Mr J Baeza

Article 21 of the Town and Country Planning (General Development Procedure) Order 1995
Application for approval of details reserved by condition 2 & 3 on BN/11/07/L
Barnham Windmill Yapton Road, Barnham,

Arun District Council have decided to **REFUSE** details reserved by condition for the

Windows

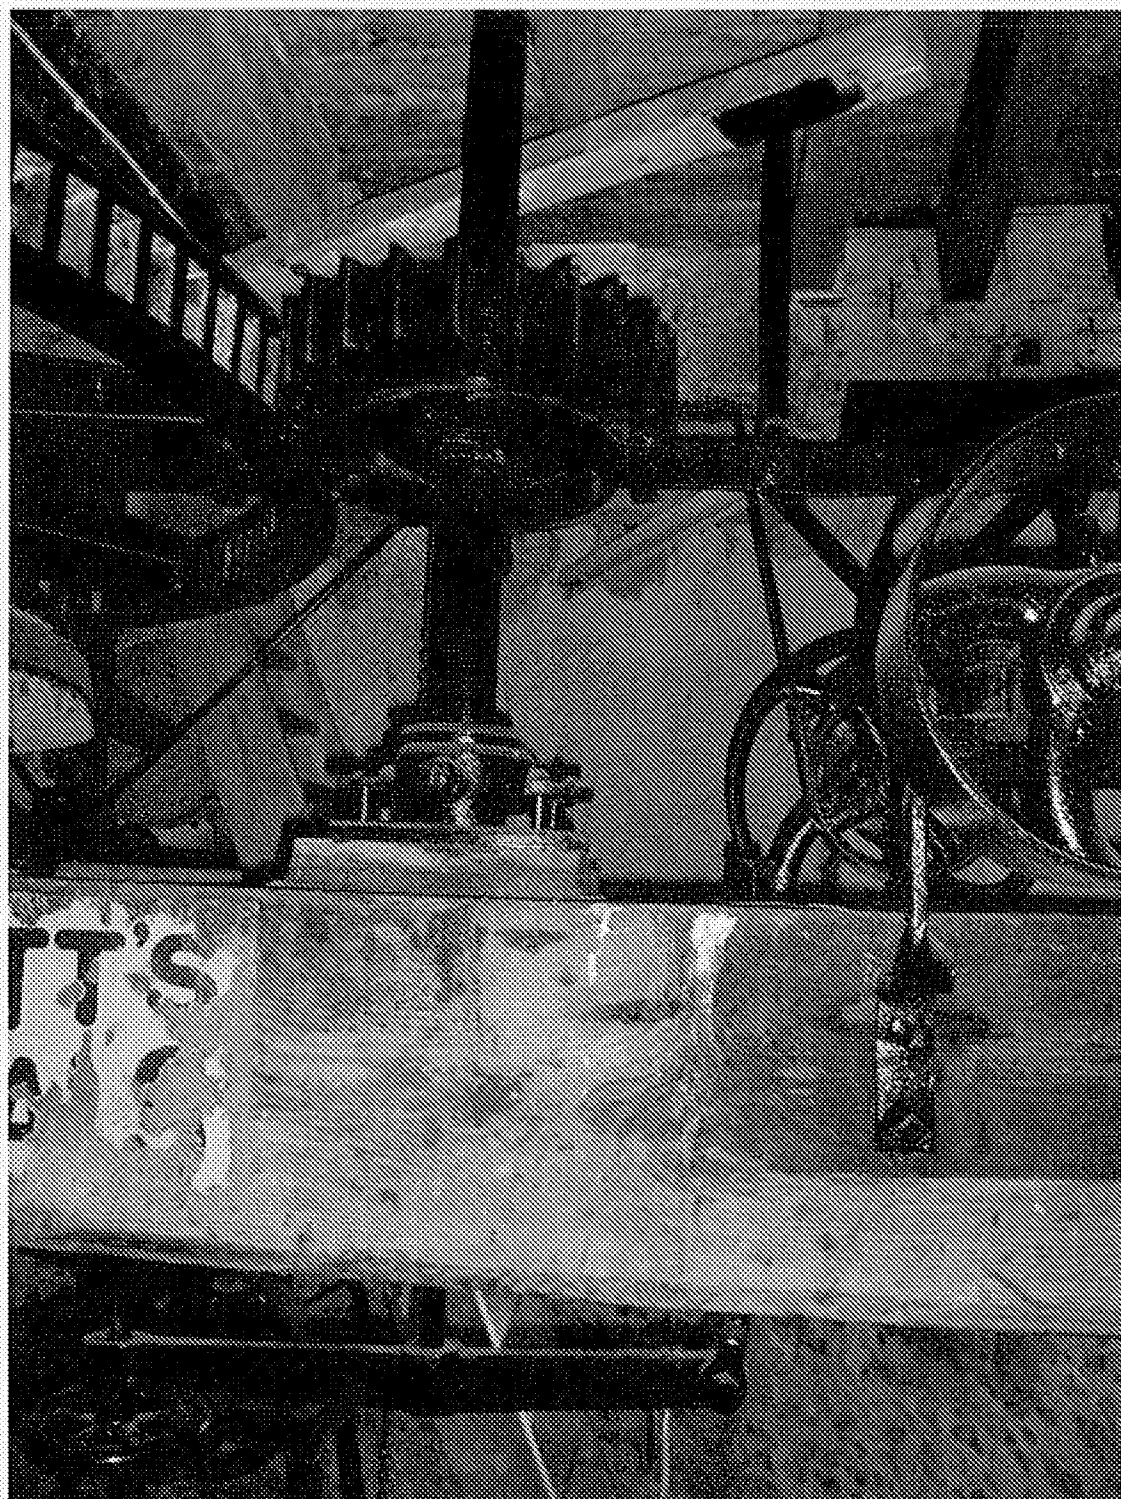
there are no details regarding the opening mechanism, measurements, glazing as required by this conditions.
